Y/38/21/L

Two new side facing conservation roof lights. This application affects the setting of a Listed Building.

Wellow Barn Hoe Lane Flansham PO22 8NT

PROPOSED SIDE ELEVATION

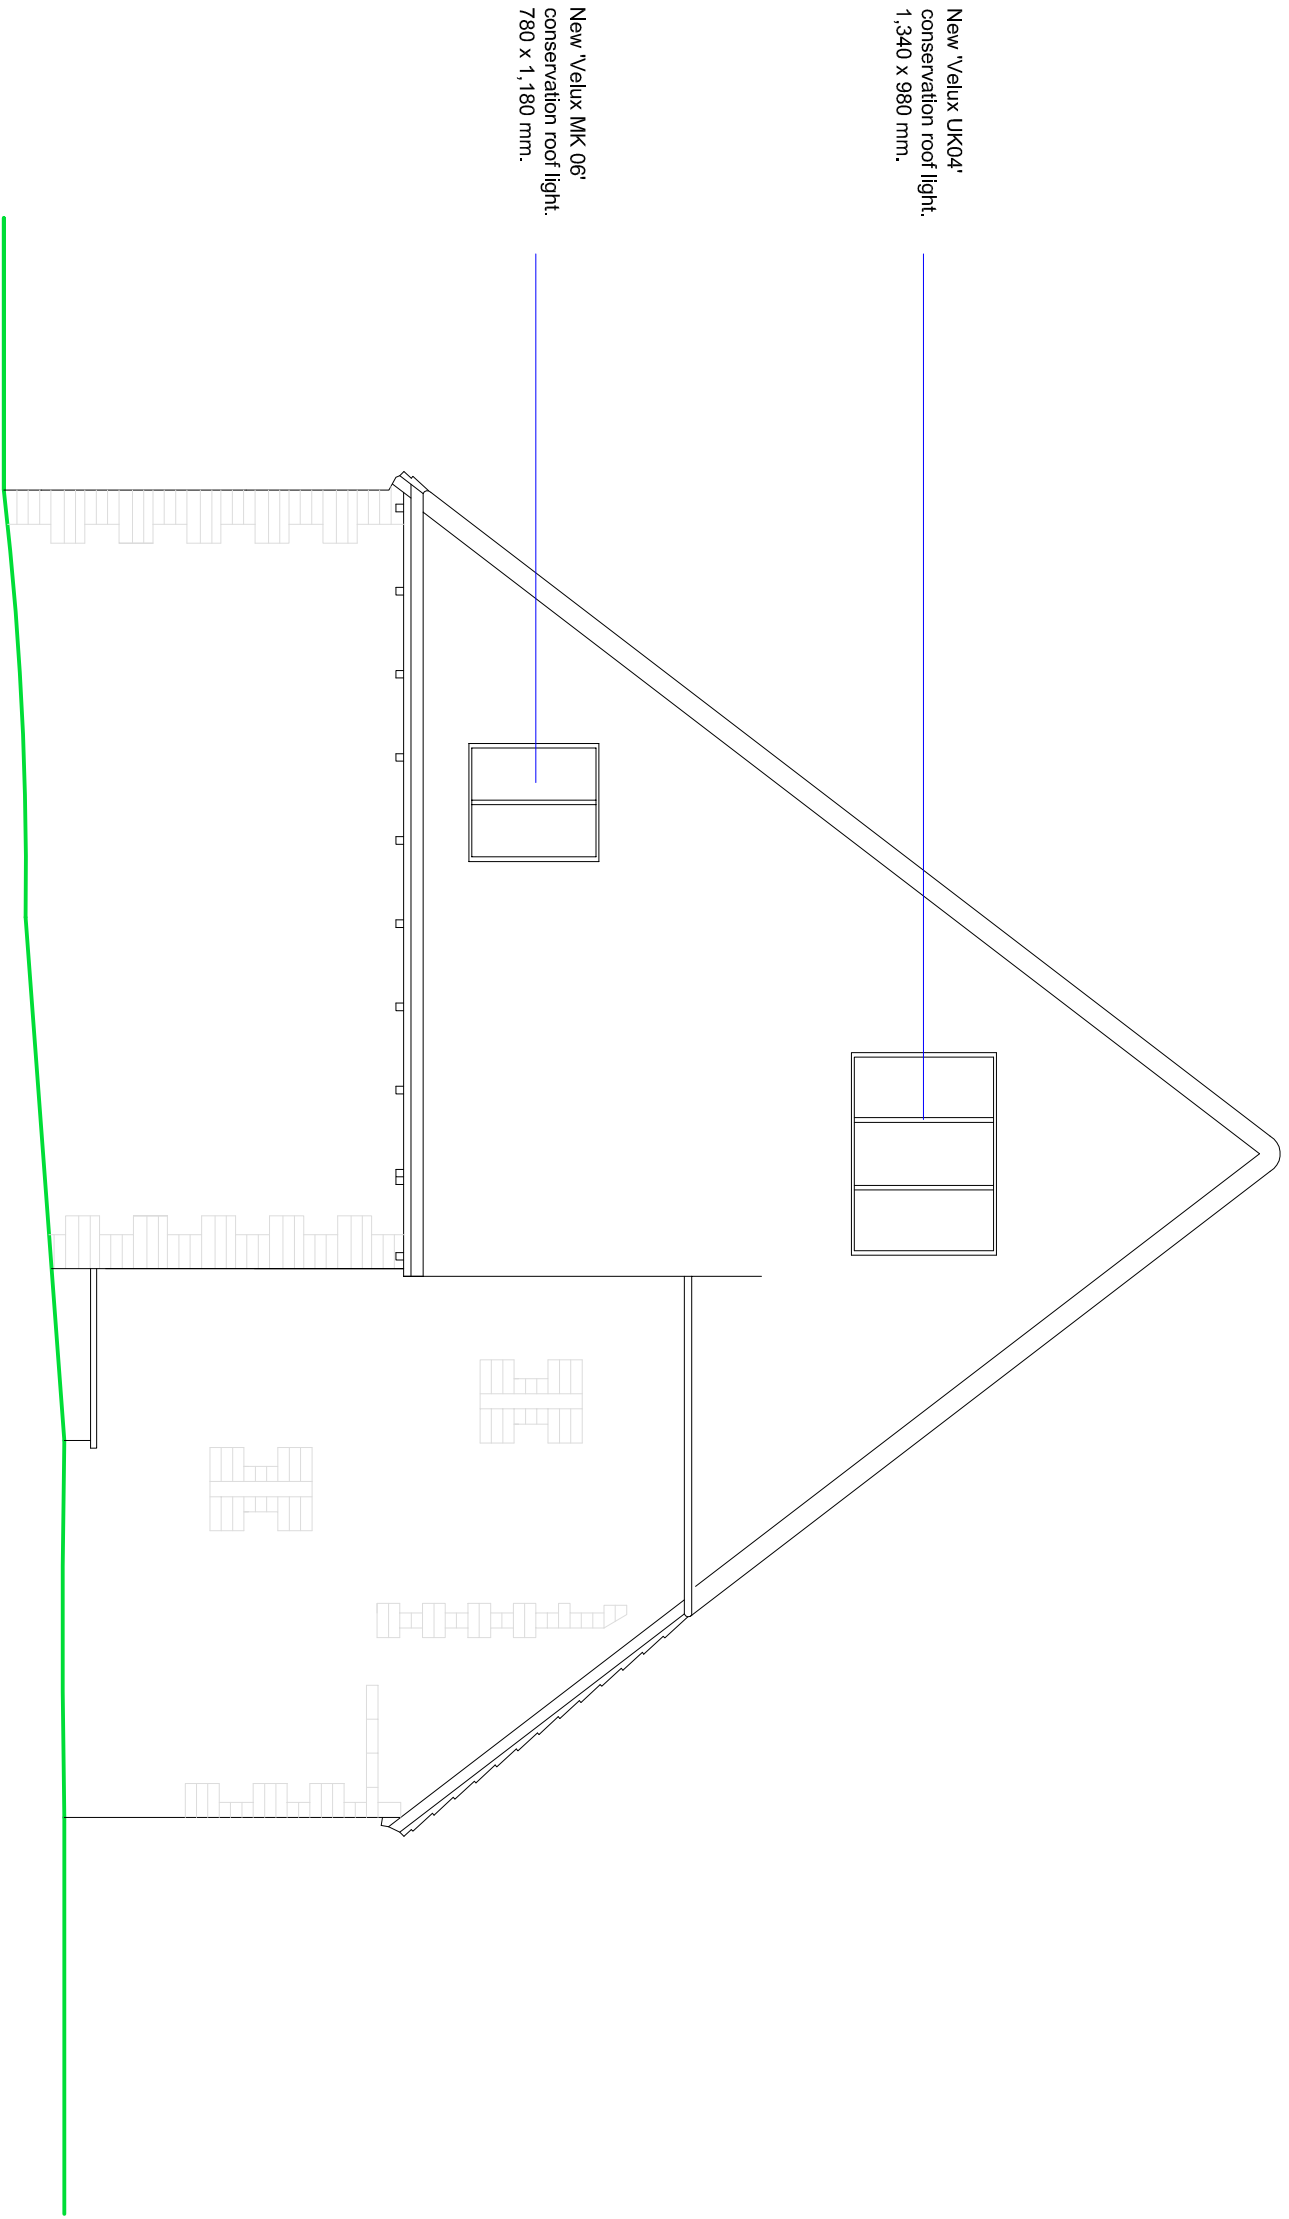
The proposal is for two new side facing conservation roof lights to one of the residential properties. Both rooflights are considered to be large, with the smallest measuring 78cm x 118 cm and the largest being 123 cm x 98 cm. These would introduce a further residential element to the building which would be out of keeping with the historic character of the structure. They would be located on an elevation which, at present, does not have any roof lights, and they would be visible from the lane when travelling along it. Their introduction could also potentially remove historic fabric from the structure.

It is also unfortunate that the additional rooflights could not be placed on the rear elevation so as to reduce the impact of the proposals.
